From: Sue Howell
Sent: 09 April 2019 17:10
To: Simon Davis
Cc: Planning.Responses
Subject: RE: Planning Consultation on AL/20/19/DOC

All good on this one now, happy to recommend the landscape discharge of condition 4 on application AL/20/19/DOC.

BOGNOR
BG.8.03.M

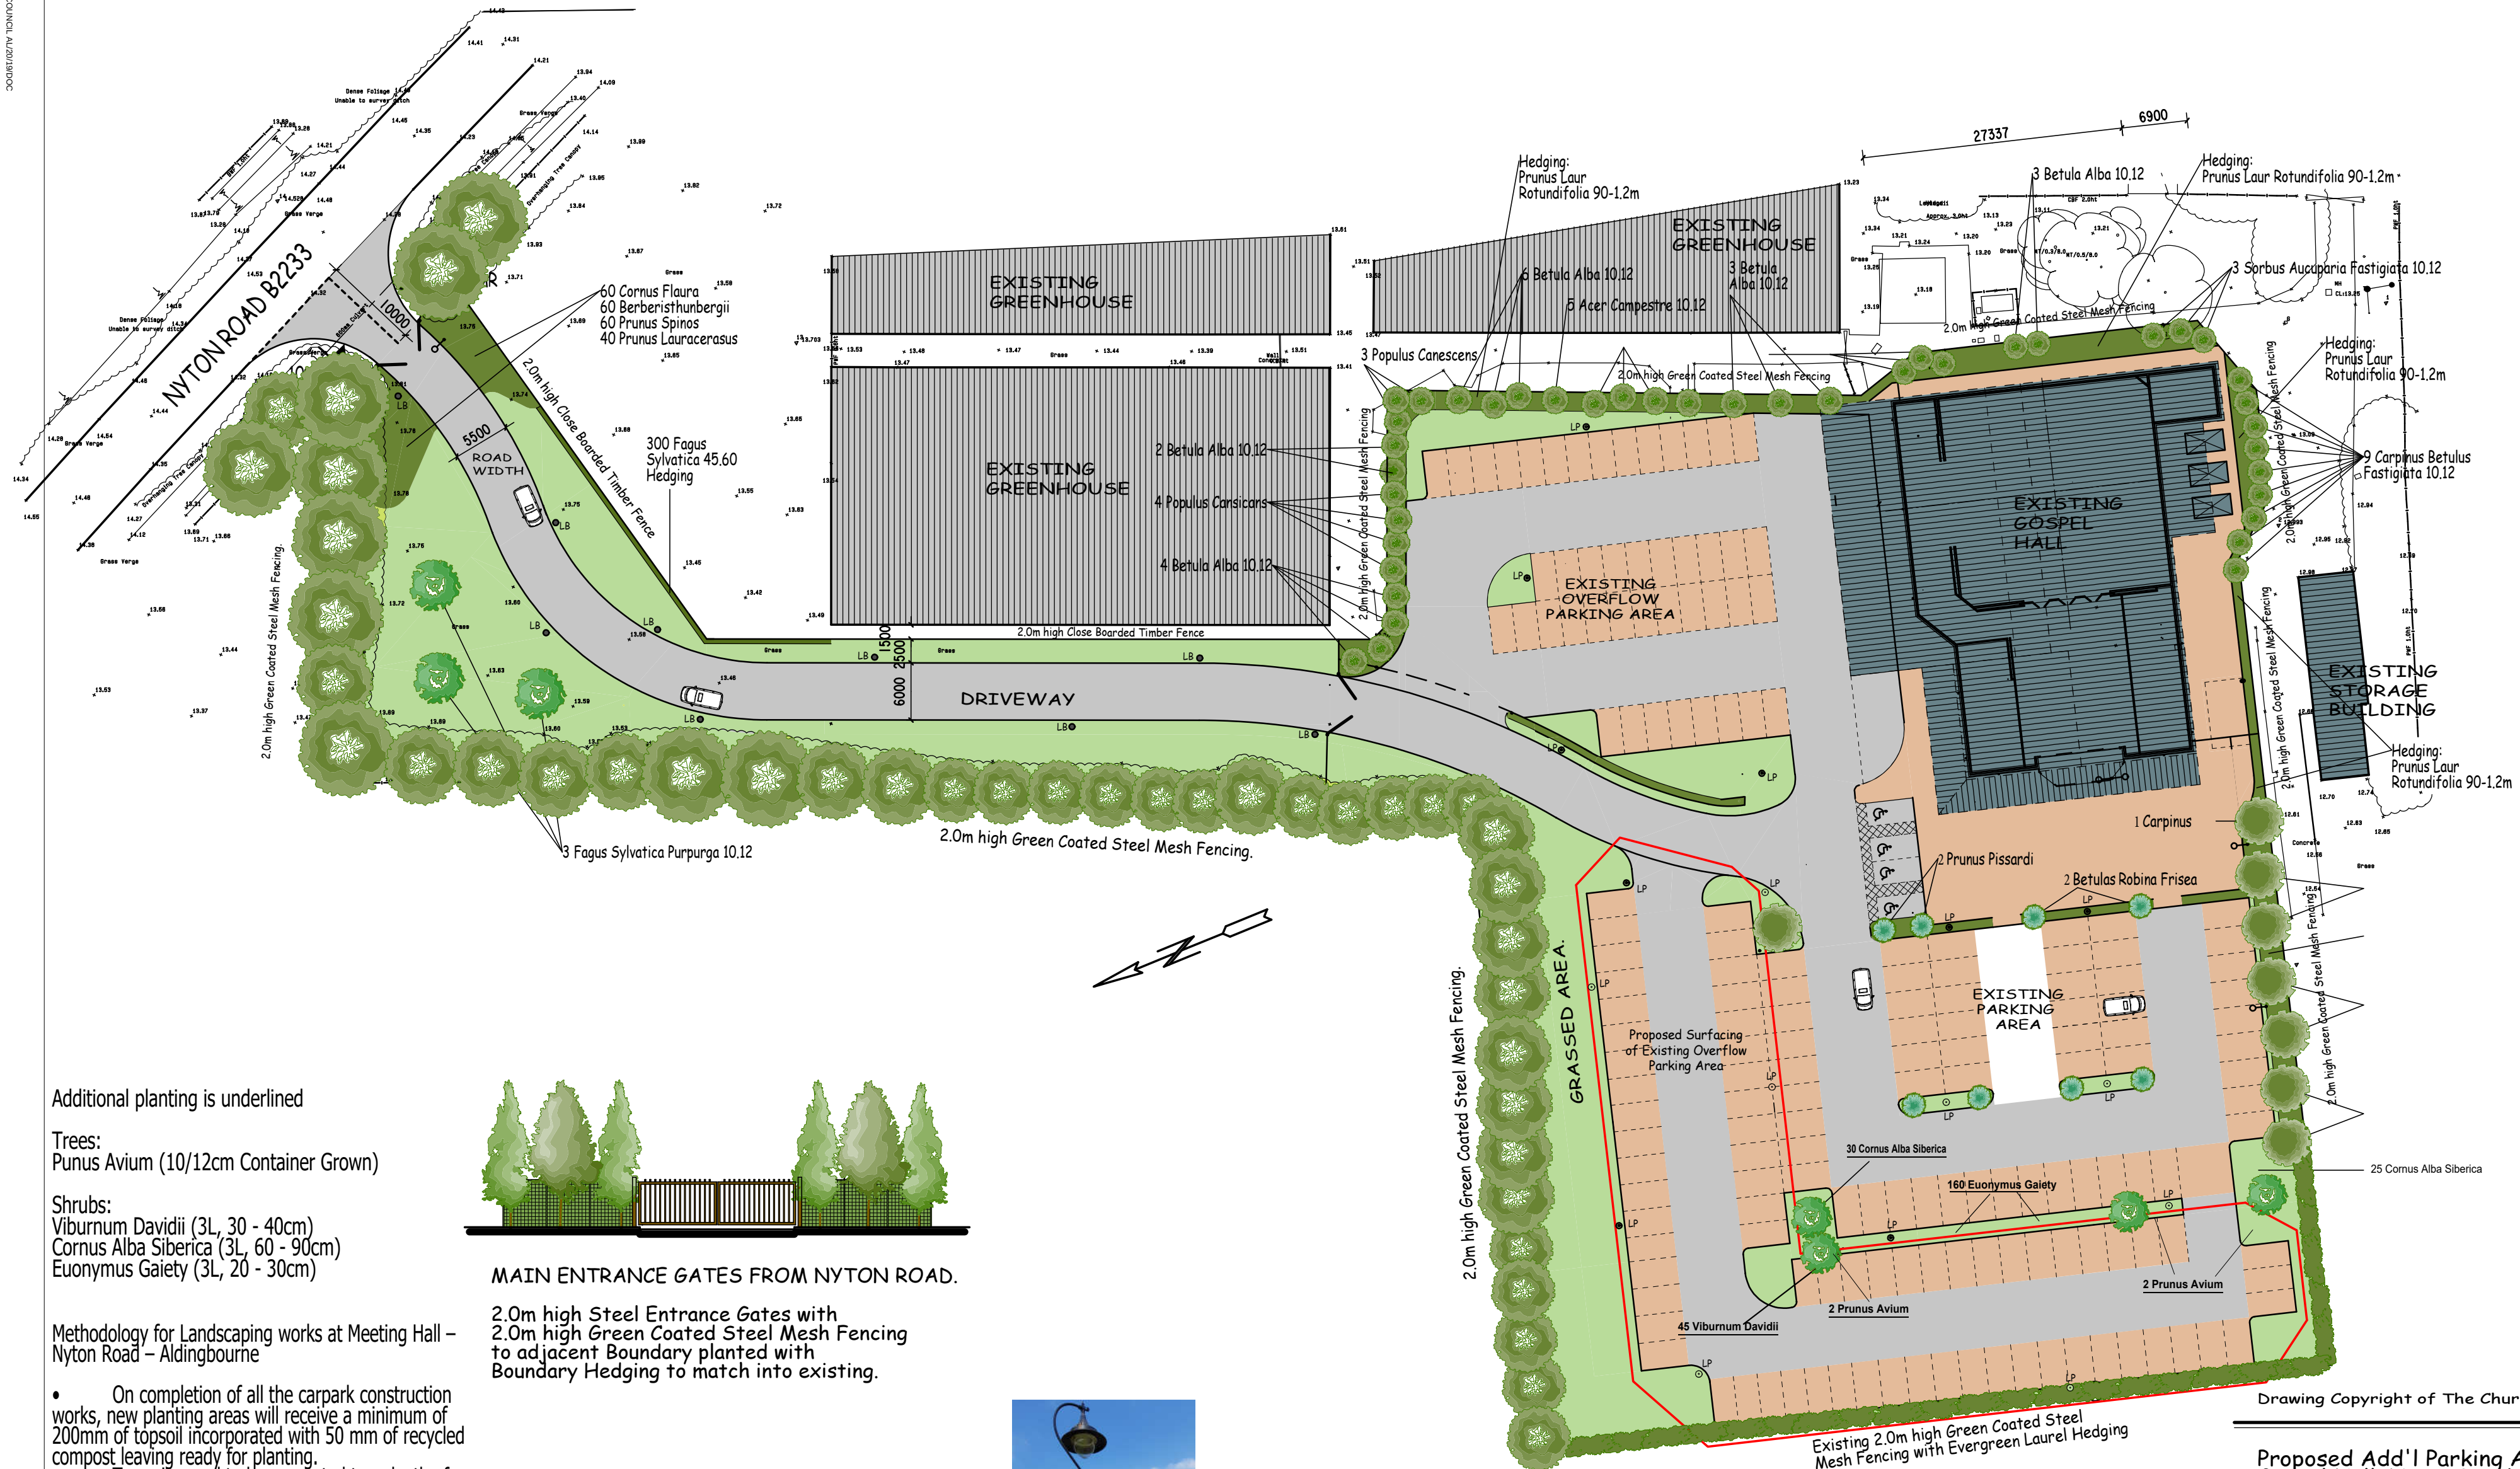
The information supplied in Dwg BG.8.03.M sets out the planting for the site, but it is a little unclear which is existing and which is the new proposed planting as part of this application.

I would recommend that further detail is provided to highlight which is the new planting with a detailed schedule also of quantities, species choice and size at time of planting.

I would recommend that this information is submitted for approval before Condition 4 on AL/20/19/DOC could be considered for discharge.

Further version of the Aldingbourne Gospel Hall site/landscape plan attached, now with planting numbers shown as requested by Sue Howell.
